Application for Planning Permission

the proposed erection of an agricultural building

Amendments Summary

Please find below our response to the invalidation letter received on February 15th.

Drawing Information	
Drawing No.	2 Site Plan
Date	09.08.2023
Review	22.09.2023 17.02.2024

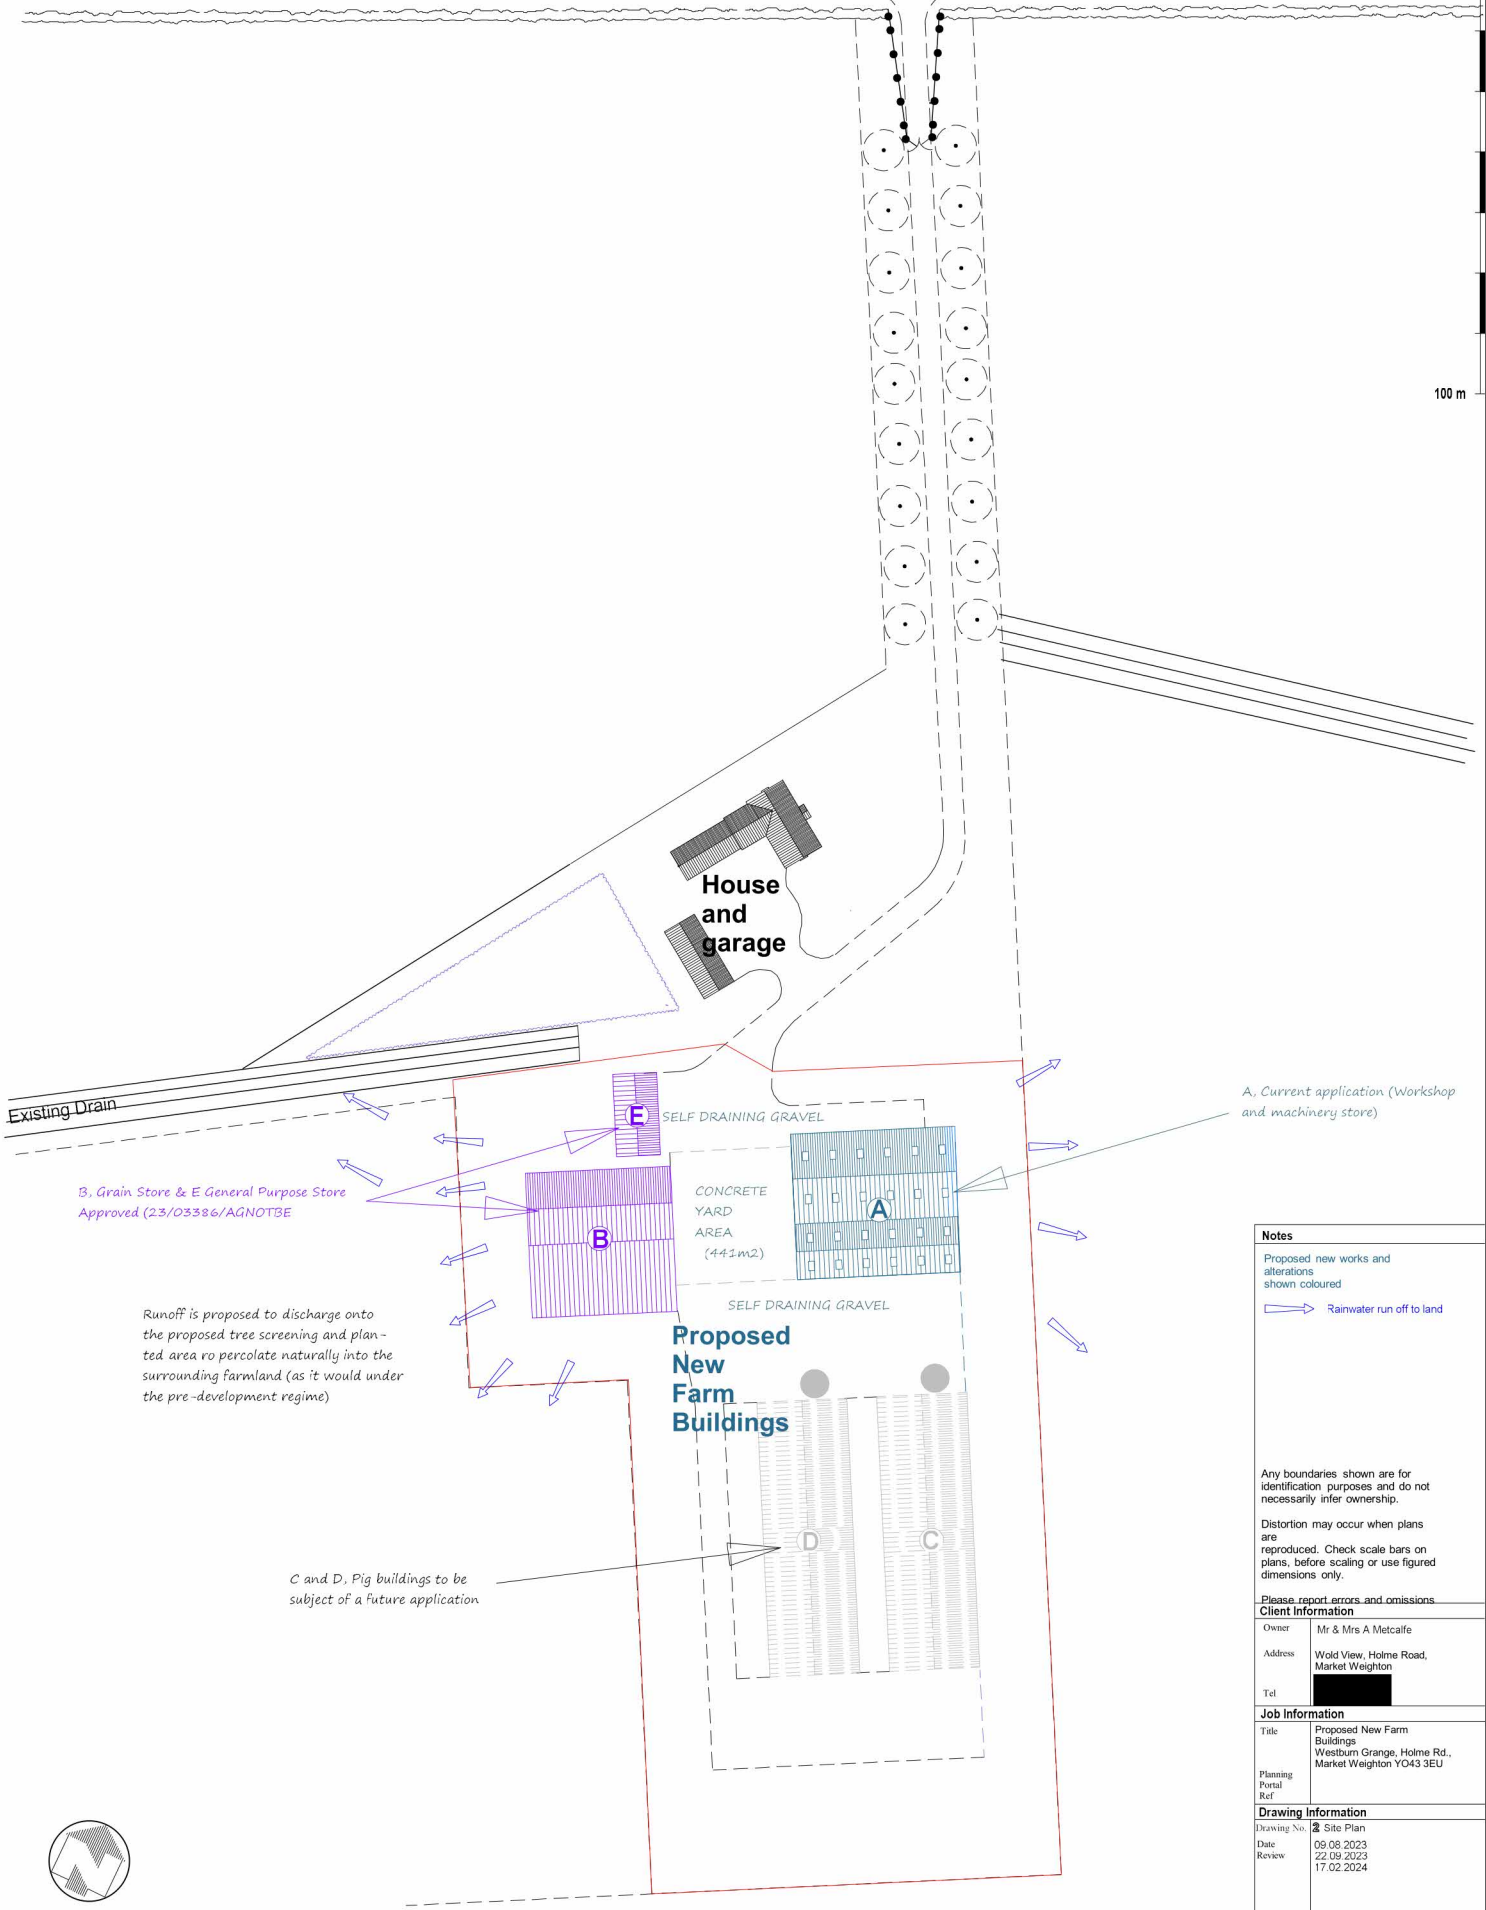
PROPOSED SITE PLAN

The following amends have been made in response to the invalidation letter:

- Annotations have been made to clarify which proposed buildings are subject to this application, which are to be subject to a future application & which have been approved via 23/03386/AGNOT
- Proposed surface water details are now shown on the plan along with any proposed areas of hardstanding
- It has been verified that the red line now corresponds with the other submitted plans

Location Plan

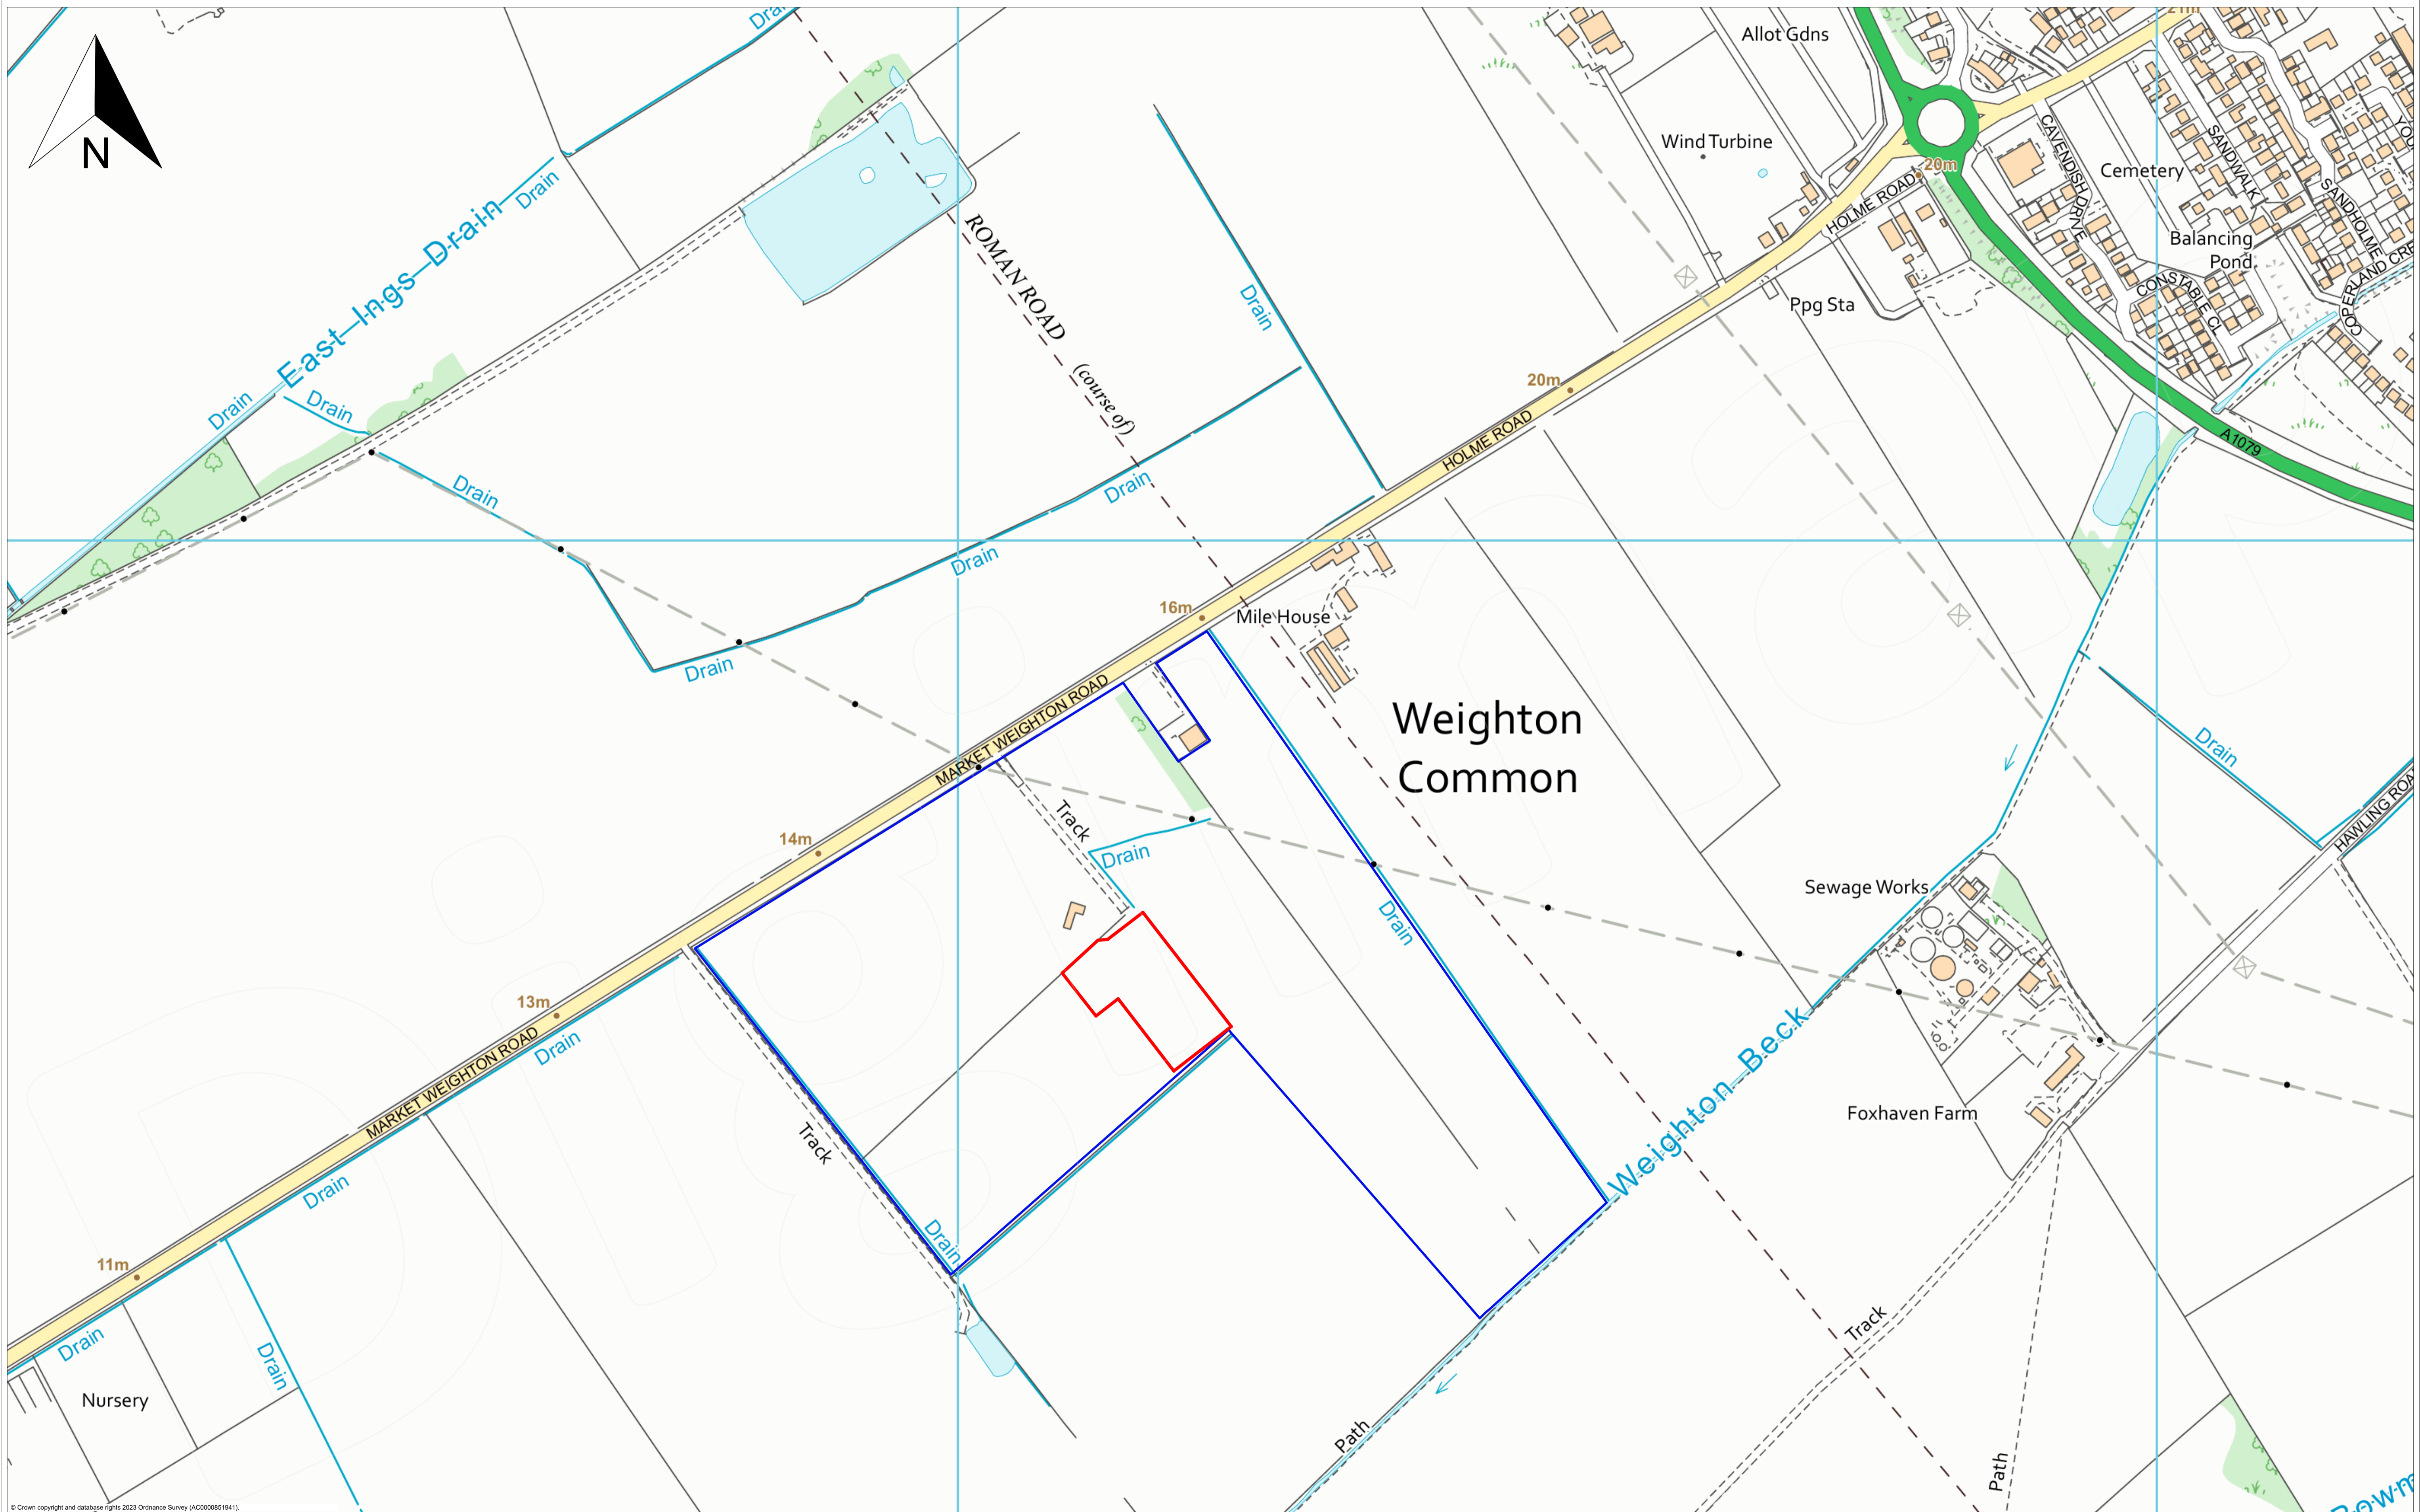
LOCATION PLAN

The following amends have been made in response to the invalidation letter:

- The error exporting to pdf has been corrected and the drawing is now confirmed to be saved/exported at 1:2500 scale
- The red line has been corrected to correspond to the proposed site plan and other plans and to correspond to the site area on the application forms (0.96ha.)
